Date 12 April 2021
Our Ref 21/00478/FUL

Town and Country Planning Act 1990 (As Amended)
Flat X, Jeal Oakwood Court, 15 St Martins Avenue
Change of use of an existing residential flat to office/administration use by the owner -
Epsom and Ewell Housing Association: minor internal adaptations proposed only.

Site plan and Ground floor plan

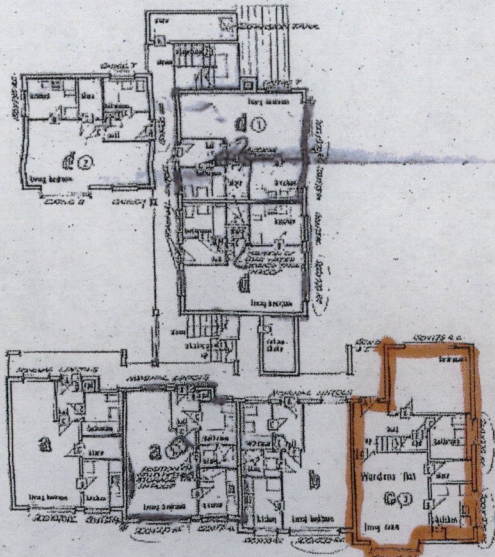
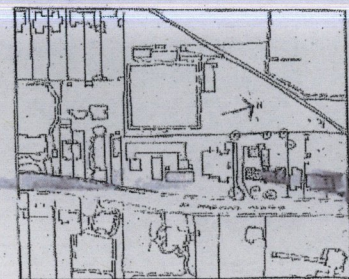
2 The drawings that have been submitted do not allow us or members of the public to adequately determine the siting and appearance of the proposed development. Detailed drawings must be provided, which should clearly show the relationship of the development with the application property and the neighbouring properties. Specifically, Floor Plans and Elevations; Please provide existing and proposed floor plans and elevations at scale 1:50 or 1:100. The drawings must include dimensions and/or a scale bar, as the plans are only available to view electronically.

Site location plan scale 1:1250

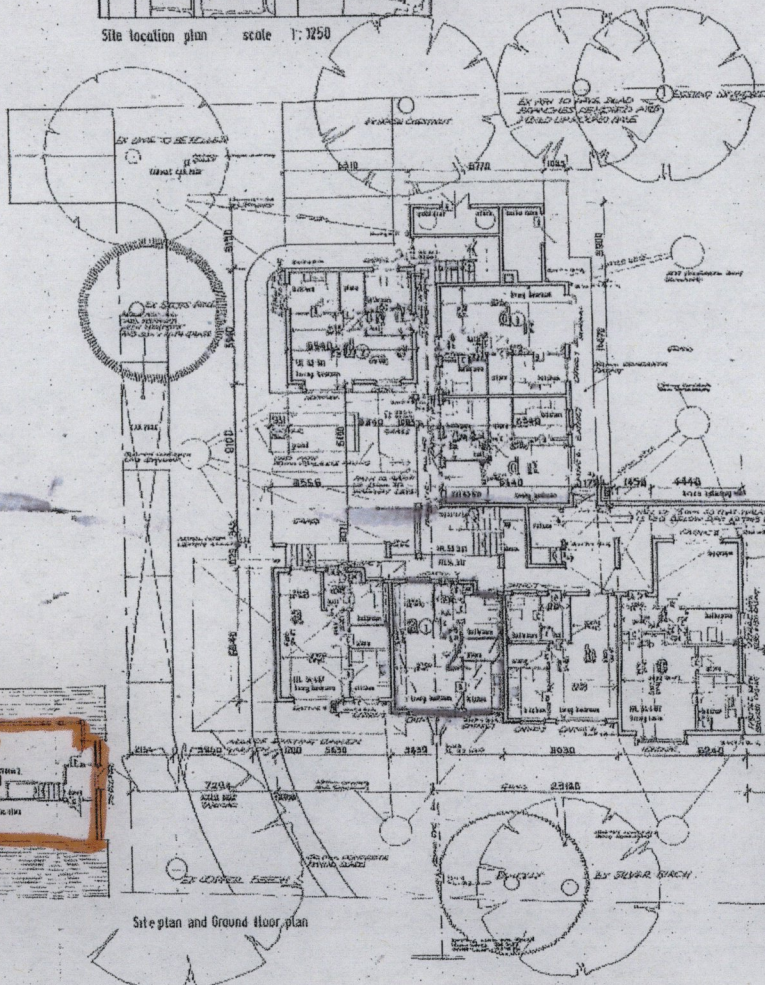
1 You must submit an accurate Site Location Plan, to a scale of not less than 1:1250 and Block Plan at scale 1:200 or 1:500. You should outline the application site in red and any adjoining land in the same ownership in blue on the Site Location Plan.
